Highways Development Management Shire Hall Gloucester GL1 2TH	
Red House Brockhollands Nr Bream Glos GL15 4PP. Mr Alan Challenger juliasibley92@gmail.com		email: richard.jefferies@gloucestershire.gov.uk	
Our Ref: F/2023/053498		Your Ref: F/2023/053498/PRE	Date: 24 August 2023
Proposal:	Proposed new dwelling in garden of property	Received date:	22 August 2023
Document(s), drawing(s) and reference(s):	Pre-application enquiry including supporting information.	Planning history ref(s):	N/A.
<u>GCC Pre-Application Advice</u>			
<p>Thank you for your pre-application enquiry received in my department on the 22nd August 2023. Regarding the pre-application submission, I have the following comments to make from a highway planning perspective and these points will need to be addressed at the next application stage.</p> <p>The principle of the proposed development for the erection of 1 dwelling within the applicants site curtilage via existing access from Brockhollands Road can be acceptable so long as the proposed vehicular access arrangement can provide sufficient emerging visibility and a safe and suitable access arrangement so vehicles can enter and exit the site without conflict.</p> <p>A

PROPOSED PART SITE PLAN 342.03 1:200 December 2023

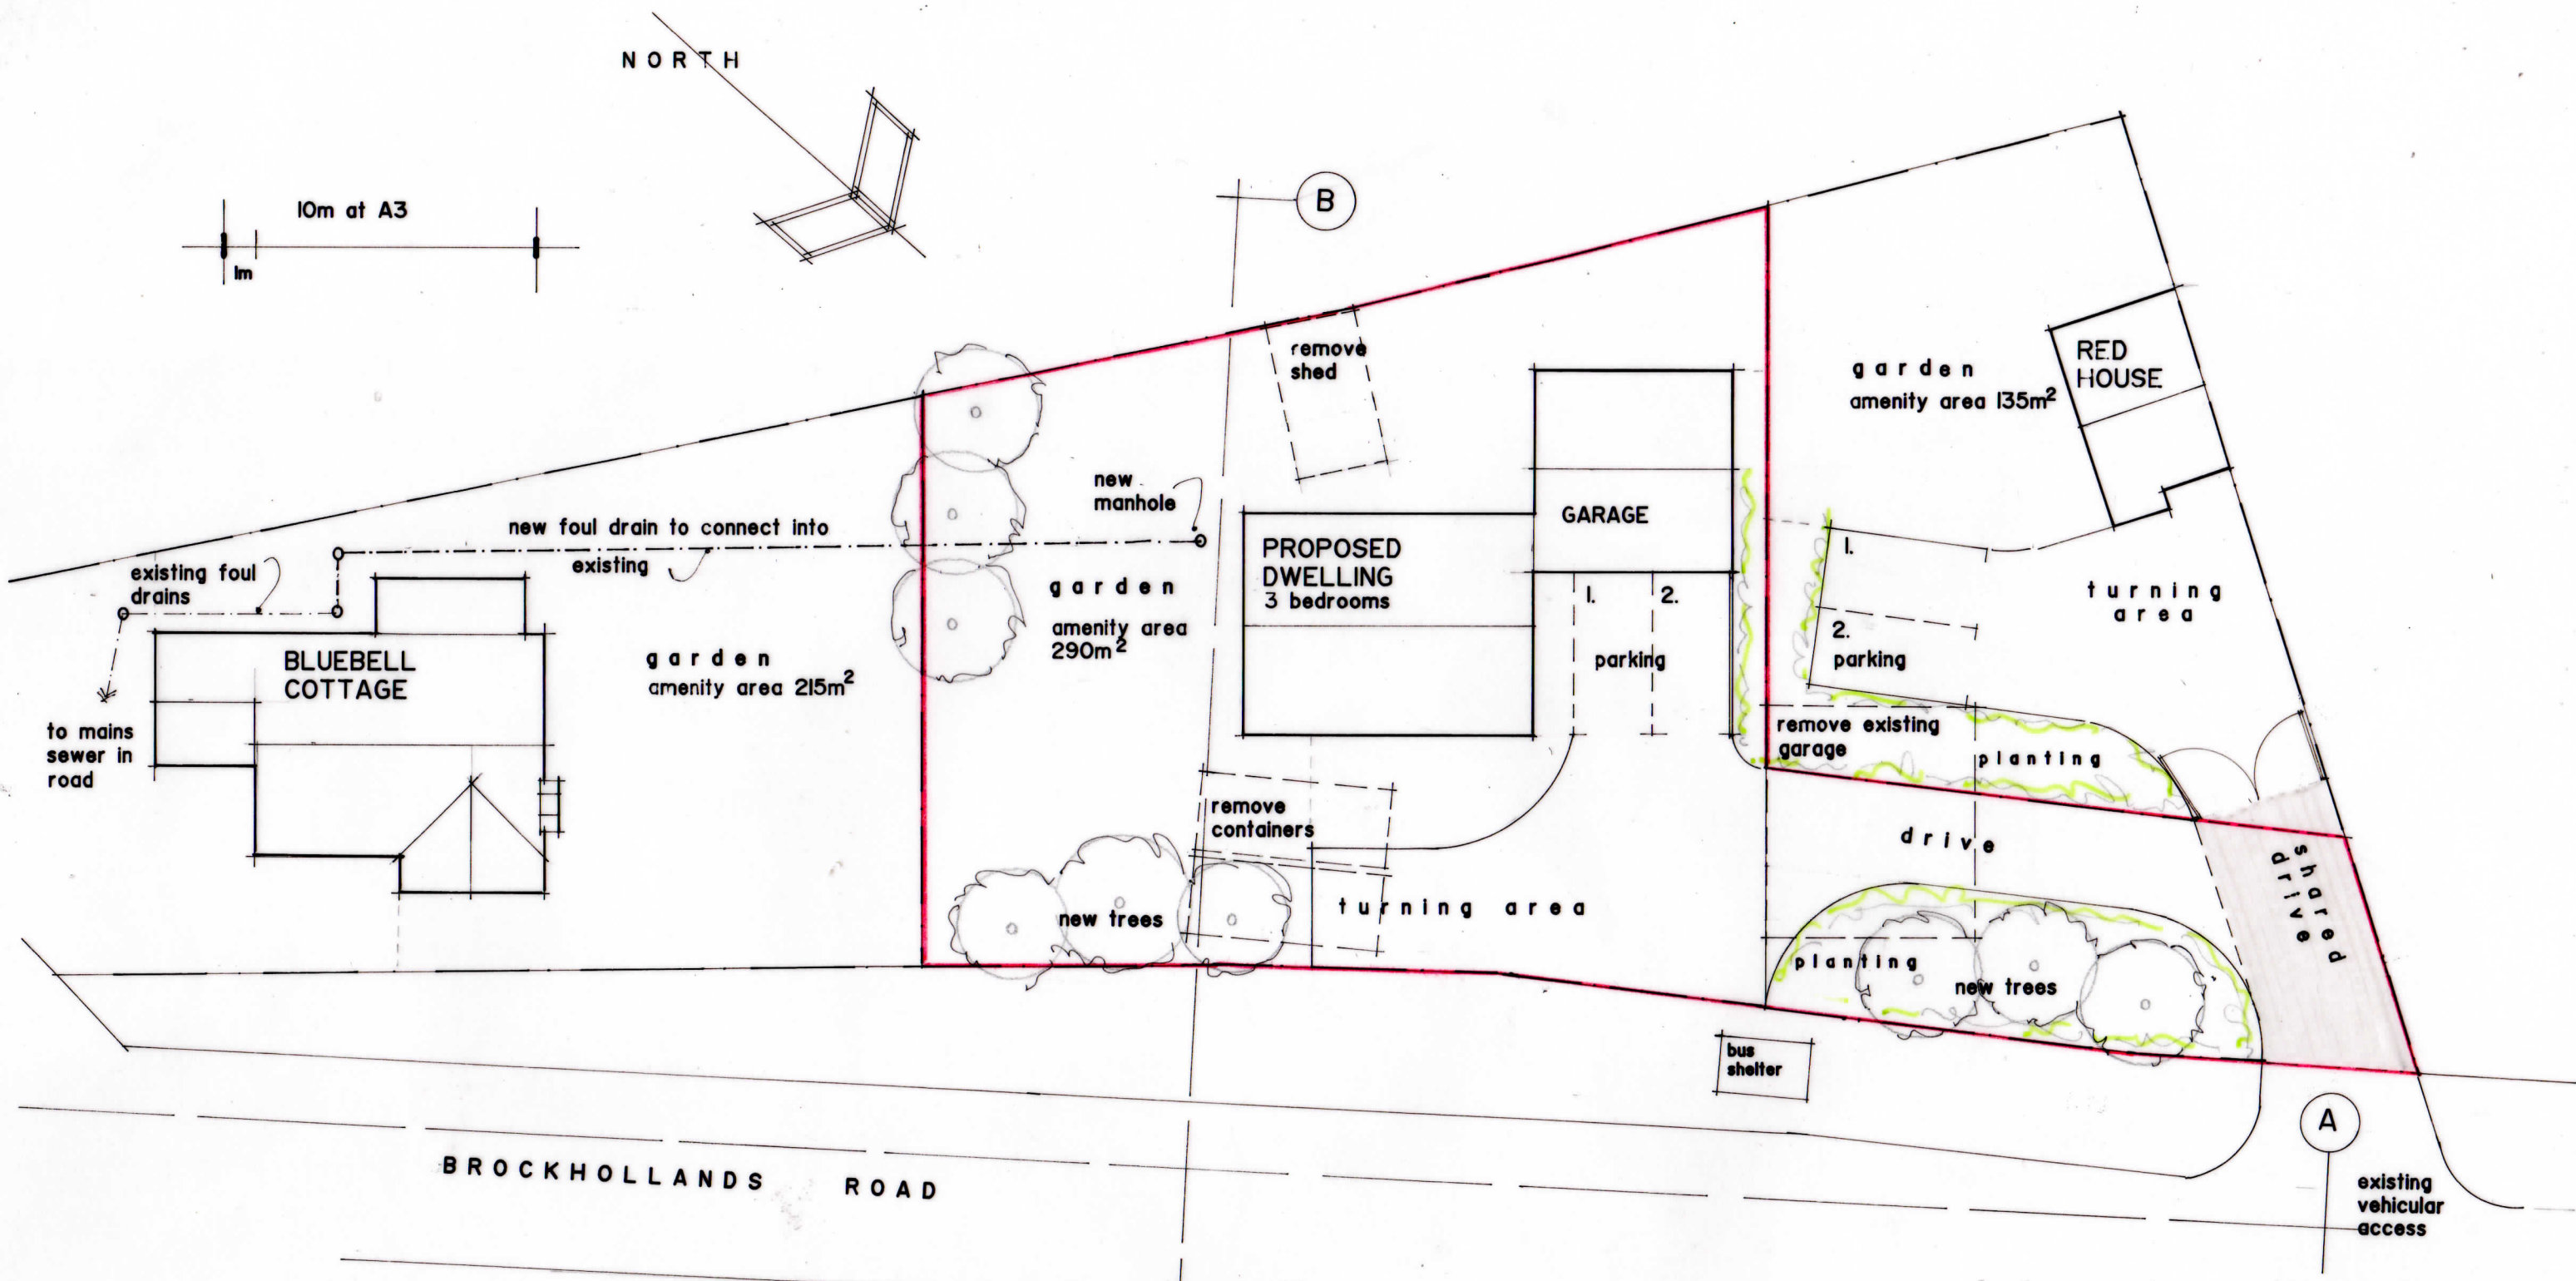
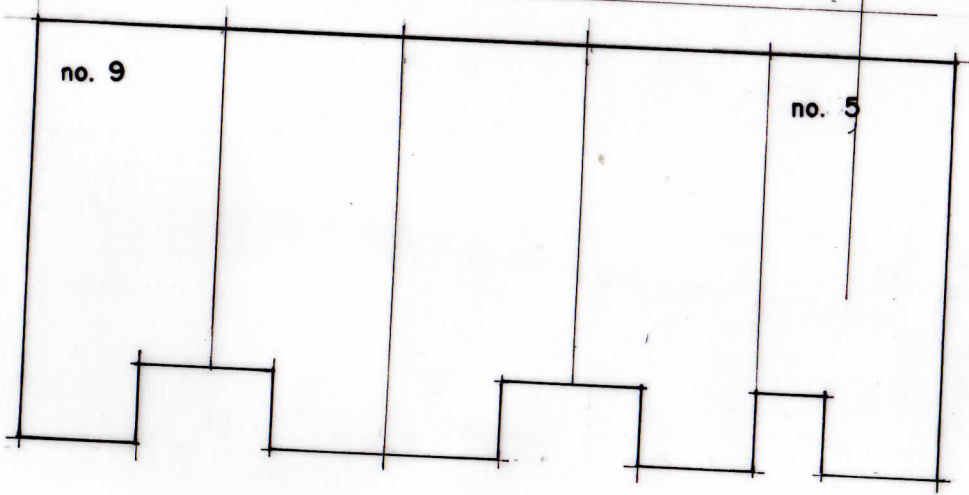
At full application stage speed survey data to be submitted along with an annotated plan to demonstrate emerging visibility splays which have been derived from the speed survey data (85th percentile speeds/traffic volumes).

FOR INFORMATION - GCC would in every instance require a design compliant vehicular access arrangement to the proposed development site, when serving two or more properties (up to ten dwellings) the access/driveway can be of varying width but must be a minimum entry width of 4.1 metres for the first 15 metres leading into the site to allow two vehicles to enter and leave simultaneously. Any gates to be set back 5m from the carriageway edge and gates to be hung and open inwards into the site with the area of driveway within at least 5.0m of the carriageway edge of the public road surfaced in bound permeable material and drained so as no surface water runs onto the highway.

Suitable turning facilities will be required within the site so as vehicles can enter, turn, and park and leave in a forward gear to be confirmed and demonstrated with the use of swept path analysis.

The layout should be subject to the County's Technical Specification for New Streets guidance and Manual for Gloucestershire Streets July 2020, footways to all dwellings of typically 2m. All parking provision to be provided within the site. Parking provided for dwellings to allow for disabled users and bin collection points which should be adjacent to refuse vehicle routing.

For the avoidance of doubt, car parking spaces must be external and address the homes for life space aspirations. Garages will not count towards the car parking regardless of their dimensions. Car parking spaces a minimum 2.4m x 4.8m. For residential dwellings circulation space around the vehicle is needed so the width should increase to 3.3m or have a 0.9m path directly alongside.

Tandem parking spaces for an individual residential dwelling is permitted but is limited to 2 vehicles. A minimum of 6m is required in front of a garage door.

Full details required at full application stage to demonstrate refuse servicing. Waste vehicles should be able to stop as close as possible to dwelling storage or collection points, and good practice is that residents should not be required to carry waste more than 30m (excluding any vertical distance) to the storage point, waste collection vehicles should be able to get within 25m of the storage point and collectors should not have to move standard two-wheel bins over 15m.
